**WELWYN HATFIELD BOROUGH COUNCIL  
EXECUTIVE DIRECTOR - PLANNING, PUBLIC PROTECTION AND GOVERNANCE**

**DELEGATED APPLICATION**

**Application No:** 6/2021/0592/HOUSE  
**Location:** 111 Eddington Crescent Welwyn Garden City AL7 4SX  
**Proposal:** Erection of a loft conversion  
**Officer:** Ms Kelsey Collins

DRAWING TITLE: PROPOSED FLOOR PLANS

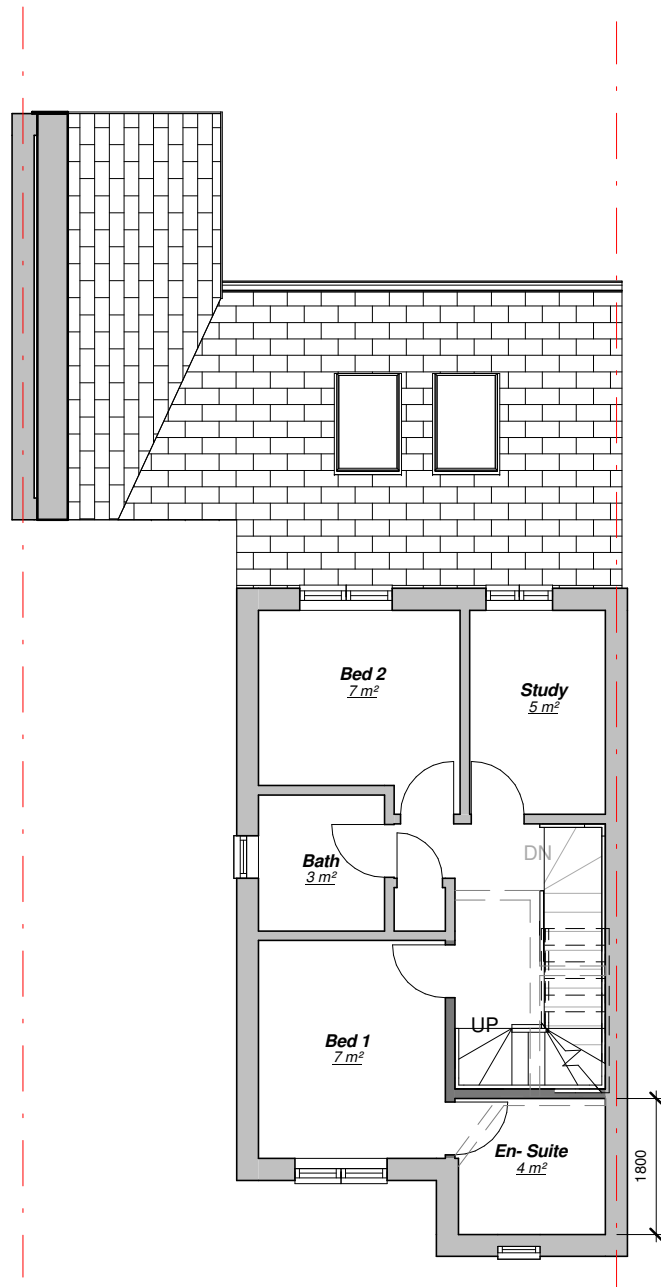
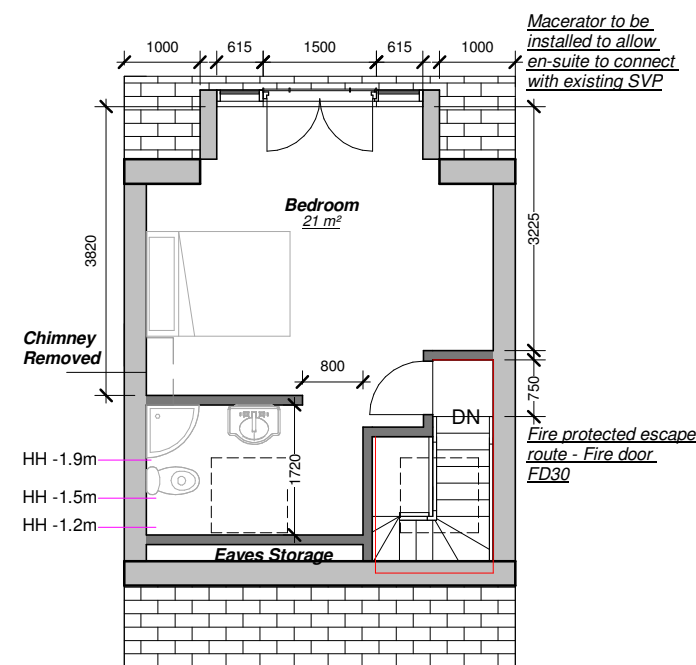
The property once extended would be a 3 bedroom property. Therefore, 3 on site car parking spaces are required. However, only two parking spaces are available on site. While there is a short fall in parking and it is noted that a neighbour objection was received in relation to parking conditions within the area. The previous application for the rear dormer 6/2019/1417/HOUSE was approved and it was noted within this application that the neighbouring property No.107 Eddington Crescent application 6/2019/0396/HOUSE was approved with a shortfall in parking as it was found on balance that the level of harm would not justify the warrant of refusal of planning permission in that case for inadequate on-site car parking.

Therefore based on previous applications and the neighbouring permission for No. 107, it is considered that the proposal would comply with Policies D1 and M14 of the District Plan 2005, the Supplementary Design Guidance 2005, the Supplementary Planning Guidance on Parking Standards 2004 and the National Planning Policy Framework 2019.

Based on the recent planning permission for the property under LPA 6/2019/1417/HOUSE and the one given for No.107 under LPA ref 6/2019/0396/HOUSE, it is considered that no objections are raised with regard to parking. Accordingly, the proposed development is therefore considered to comply with Policies D1, D2 and M14 of the Welwyn Hatfield District Plan 2005 and the NPPF.

**DRAWING TITLE:** PROPOSED ELEVATIONS

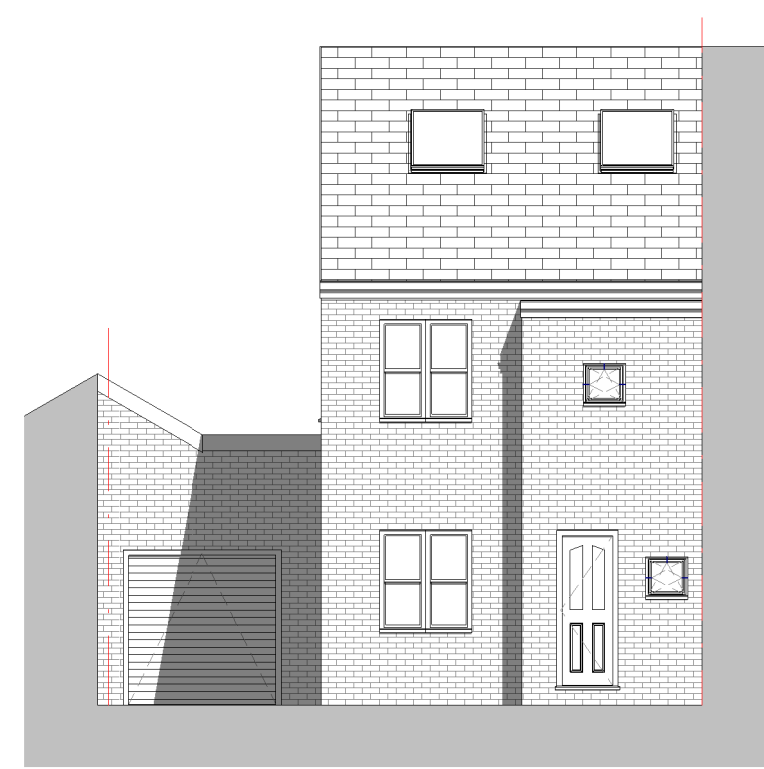
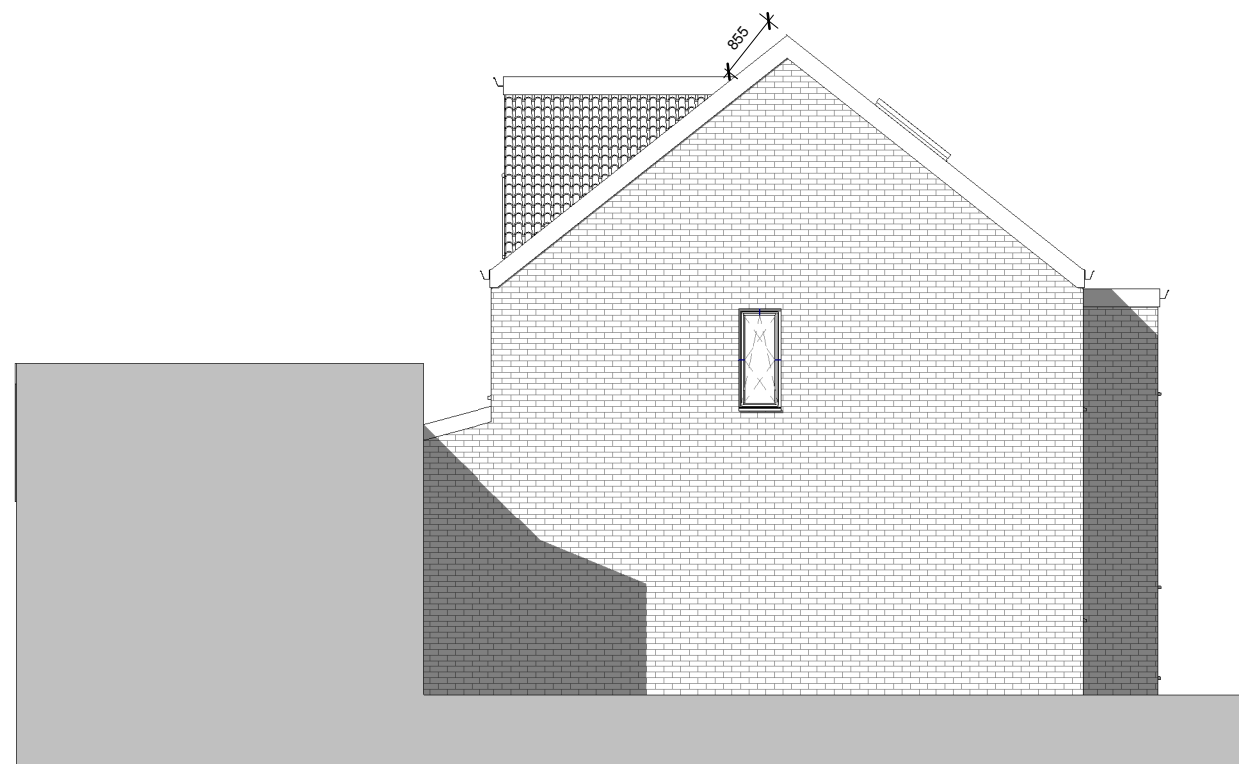
It is acknowledged that the dormer proposed would result in an additional impact and some overlooking towards No.113 Eddington Crescent rear amenity space. However, while it is noted that no objections have been received in relation to overlooking or loss of privacy, it is also noted that the extent of overlooking would be consistent with a neighbouring relationship generally expected between residential properties and would be to some extent comparable to the views from the existing first floor windows. It is therefore not considered that the scope of additional overlooking would be sufficient to be considered unacceptably harmful to the privacy of the occupants of No. 113.

For the above reasons, it is considered that while the erection of a rear dormer window would increase the impact upon this neighbour's amenity, it is not considered that this would result in such an additional impact upon the amenities of any neighbouring occupiers in respect of privacy and outlook impacts to warrant the refusal of the application.

Subject to conditions, the proposal would meet the provisions of both local and national planning policy. The proposed rear dormer window and rooflight would sufficiently preserve and relate to the character, appearance of the existing dwellinghouse and surrounding area and would not have any significantly adverse impacts on the residential amenity of neighbouring dwellings.
